CITY OF PORTLAND

January 4, 2001

RE: 70 Washington Avenue – B-2b Zone – 013-C-011

Tu Casa Restaurant – Proposed

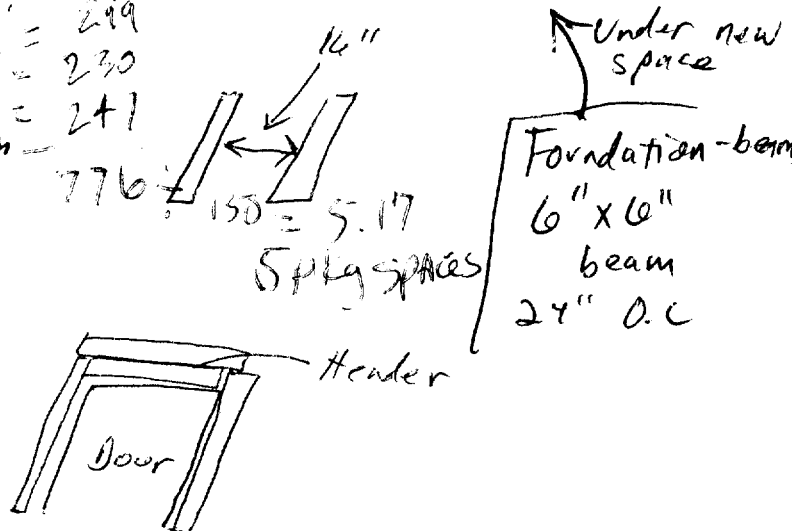
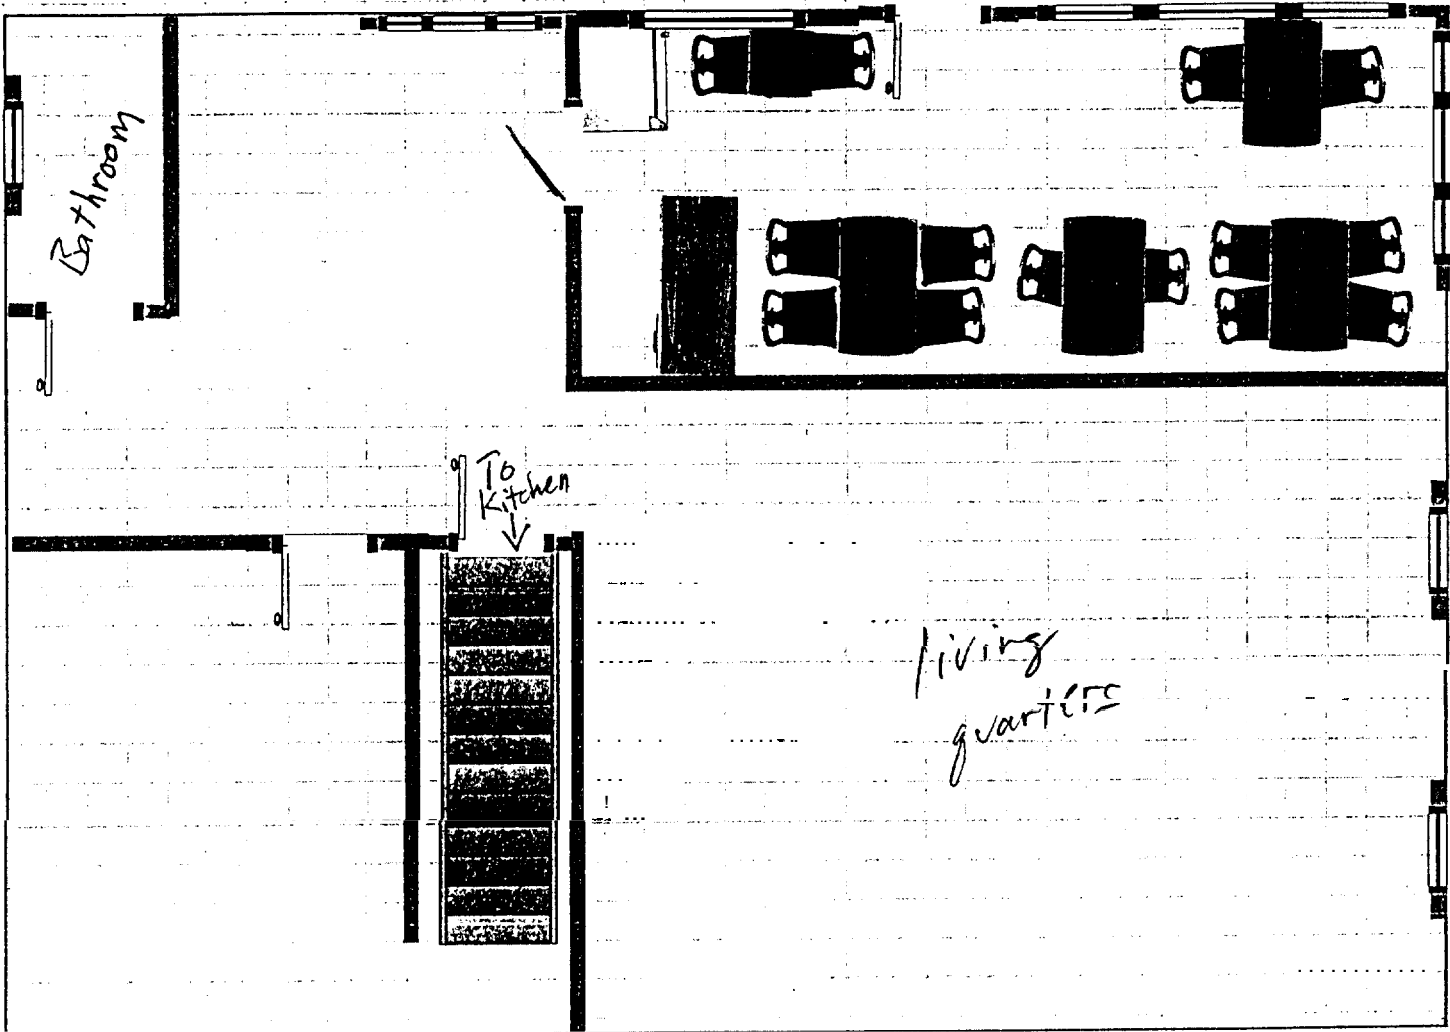
I am in receipt of your application to change the use and make alterations to your property at 70 Washington Avenue. The plans that you submitted are inadequate for determining compliance with the zoning ordinance. We will need clearer floor plans with all dimensions. Presently I am unable to determine sizes and uses of rooms. The bottom dimensions of the building add up to 32 feet and the top dimension is stated to be 50 feet. Your plans must be more clear and accurate. You are also required to submit a plot plan with parking outline. A parking space is 9'x19'. They need to be shown on your plot plan layout.
